ARBORICULTURAL STATEMENT IN RESPONSE TO TREE OFFICER CONSULTATION

17 November 2022

Site: 137 Huntingdon Road, Thrapston, Kettering

This statement is in response to the Tree Officer email consultation, dated 01/11/2022.

Project:			137 Huntingdon Road
Client:			Anthony Binns
Drawing:			Arboricultural Site Plan (Proposed)
Drawing Ref:	Rev:	Date:	
P2468-ASP02	V1	30/06/2022	
Scale:	Drawn By:		
1:200 - A3	J. Sinclair		
Based on:			Proposed Site Plan

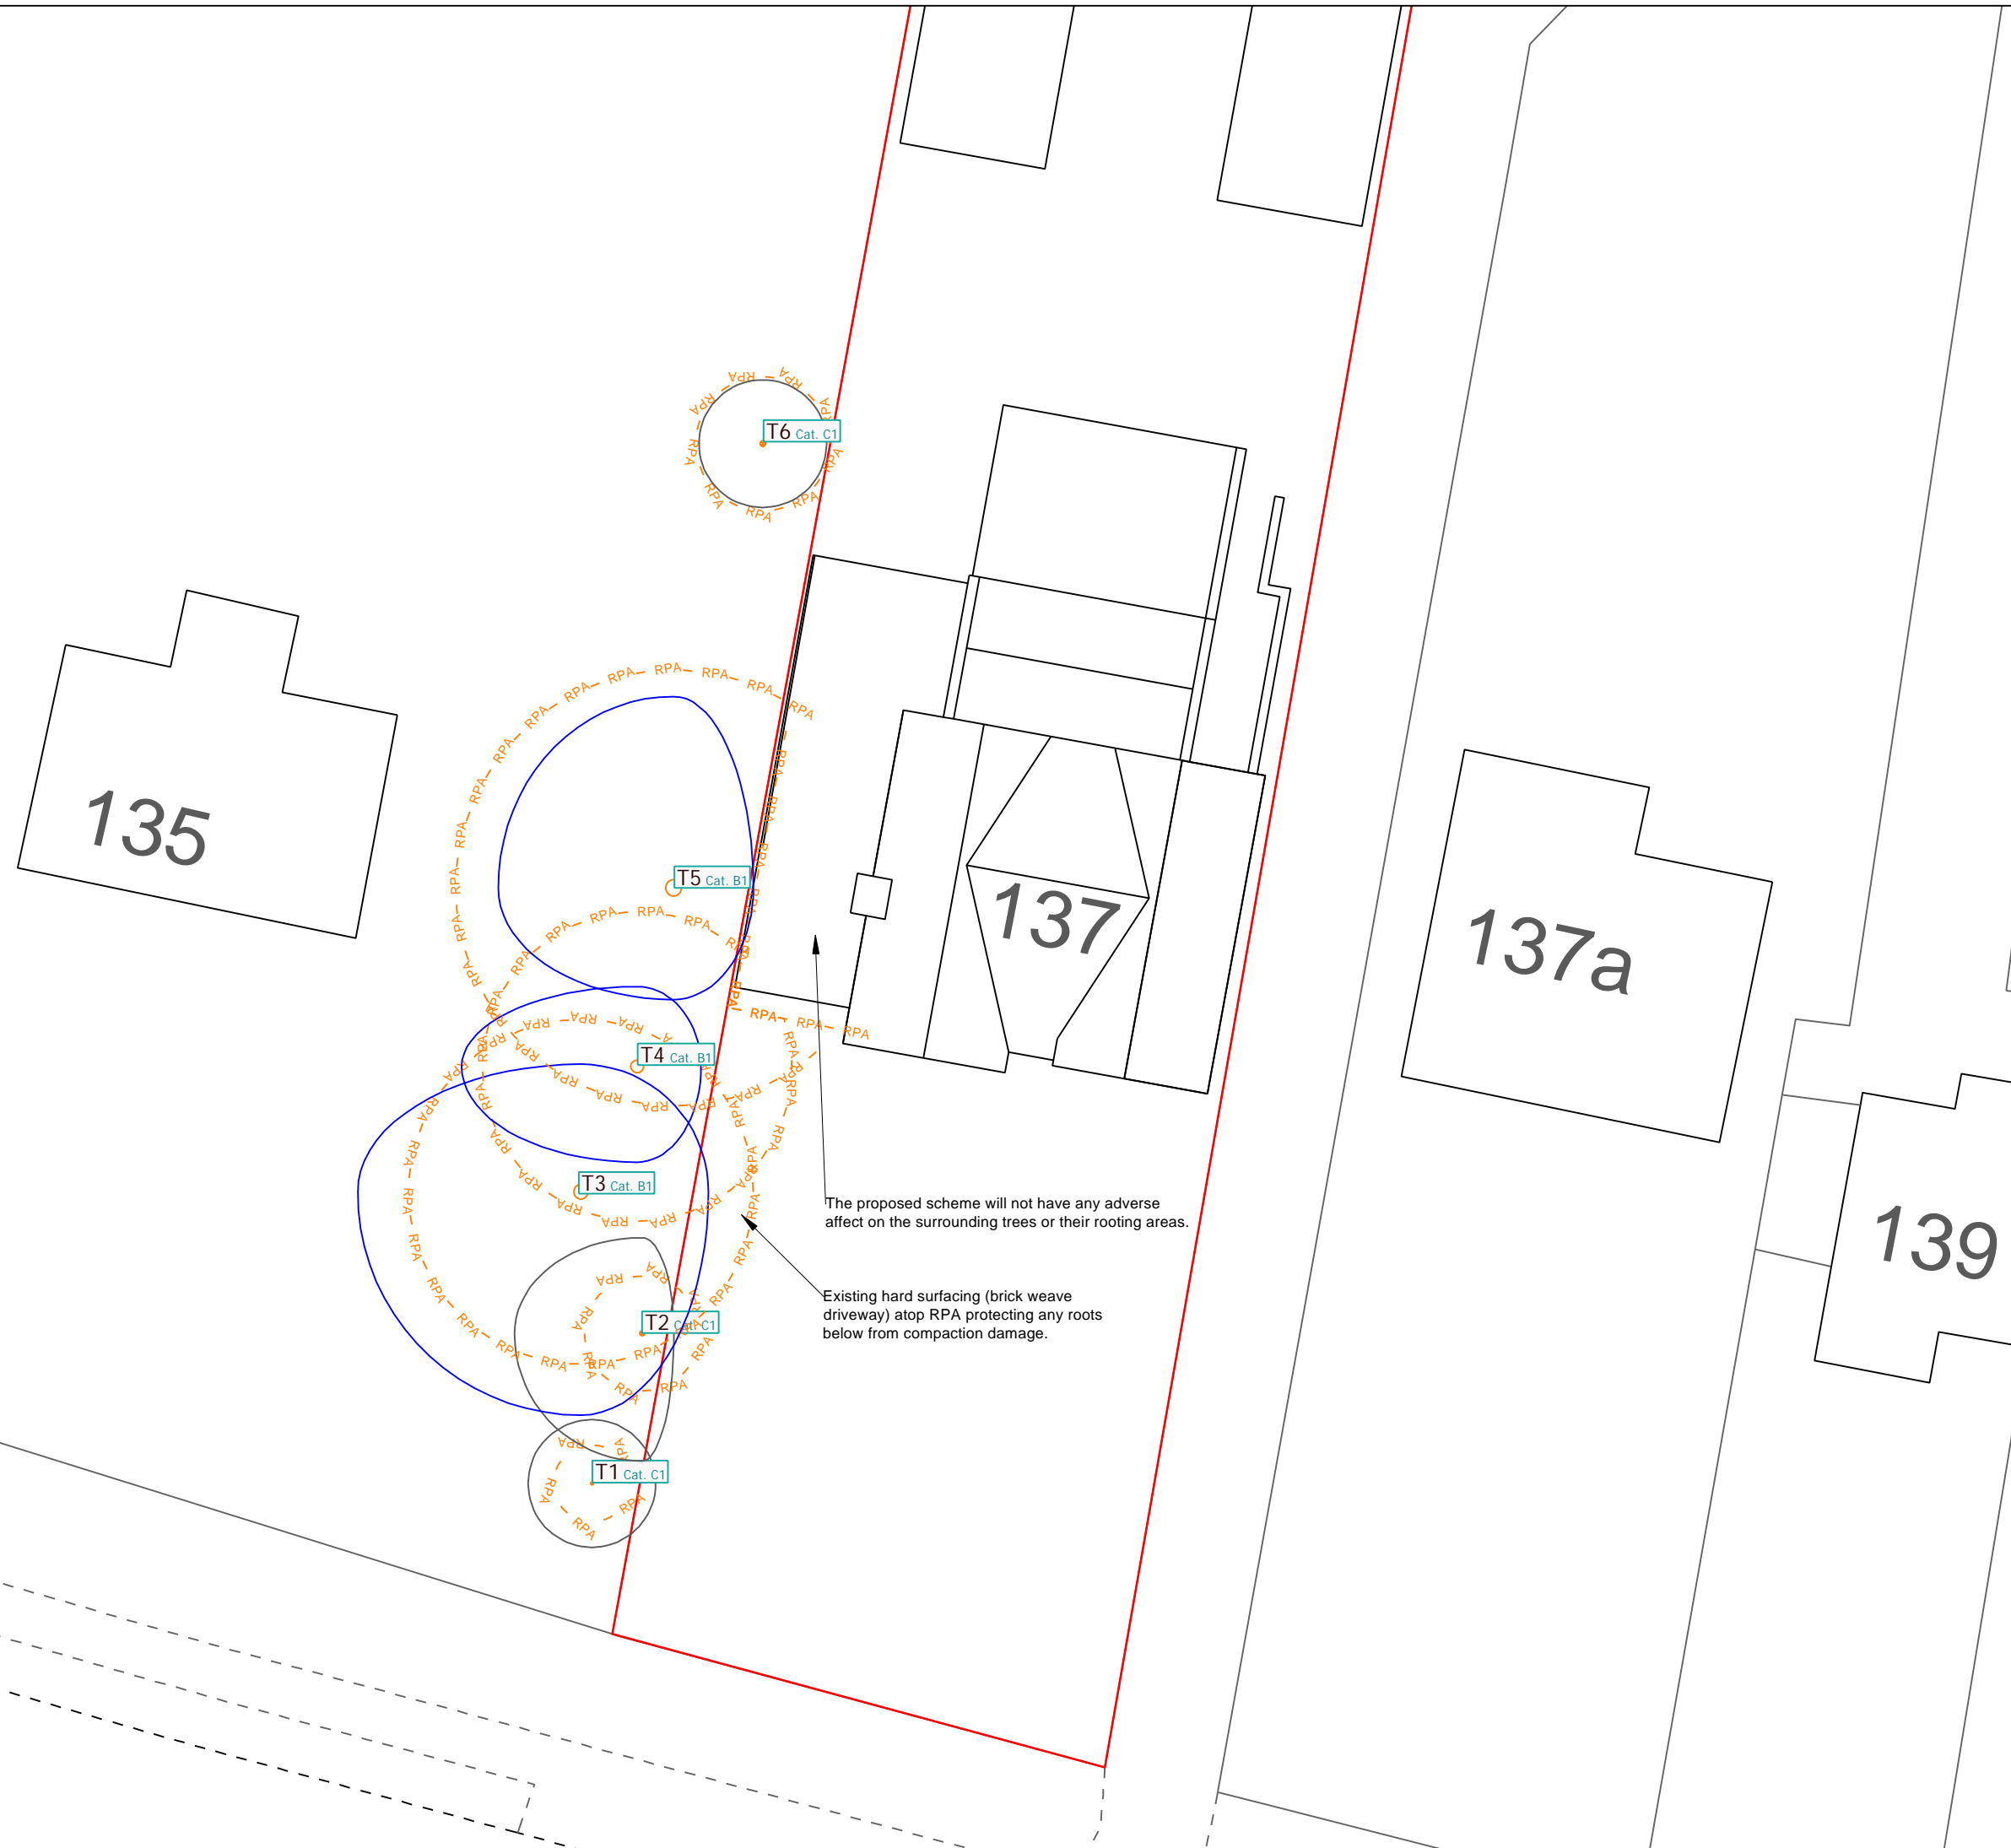
"This report hasn't explored in details the issues of post development pressure for work to the trees, and the long term sustainability of the potential relationship between the trees and any extension of the first floor into consideration. This is the principal issue of concern.

"At 3.4.1.1 the report states that "none of the trees are considered to possess a significant potential for a negative shading on the proposed extension"

"At 3.4.2.1 it states that "The layout of the scheme has been designed with consideration of the location and growth of potential of nearby trees. Owing to such, no noteworthy contention between tree canopies and property are anticipated."

The proposed extension is to be a bedroom with a window on the northern or southern side, the level of shading that can be expected will not be of concern as bedrooms are not primary living areas, and due to the bedroom's location, it will get daylight from roughly midday to sunset. It should also be noted that the adjacent trees possess relatively thin and open canopies allowing significant levels of light to penetrate.

The trees in question located on the adjacent property's boundary line are mature Austrian pine. Owing to their mature life stage, any shoot elongation is expected to be relatively slow. It should also be noted that some of the trees' eastern branches have historically been pruned back to the boundary with no growth points for regenerative growth. Therefore, it is highly unlikely that any new growth will be a cause for contention. The notion that the trees will 'require pruning periodically' doesn't take into consideration the species, and the rate of growth that can be expected for Austrian pines of a mature age. Should the trees require pruning in the future, any required works are unlikely to exceed what might be required with the current garage below.

As discussed above, the relationship between the trees and the proposed extension will not result in any more nuisance than is currently experienced with the existing garage. This is considered acceptable and not of concern by the occupant and owner of the property. They bought the house with the trees adjacent to the property willingly, they were not concerned about the debris or size of the trees when signing the contract, and their lack of concern continues to this day. The trees have historically been heavily reduced away from the property and driveway, so future similar works are not necessary. The points of concern raised by the Tree Officer are not of significant weight to legitimately object to the scheme on.
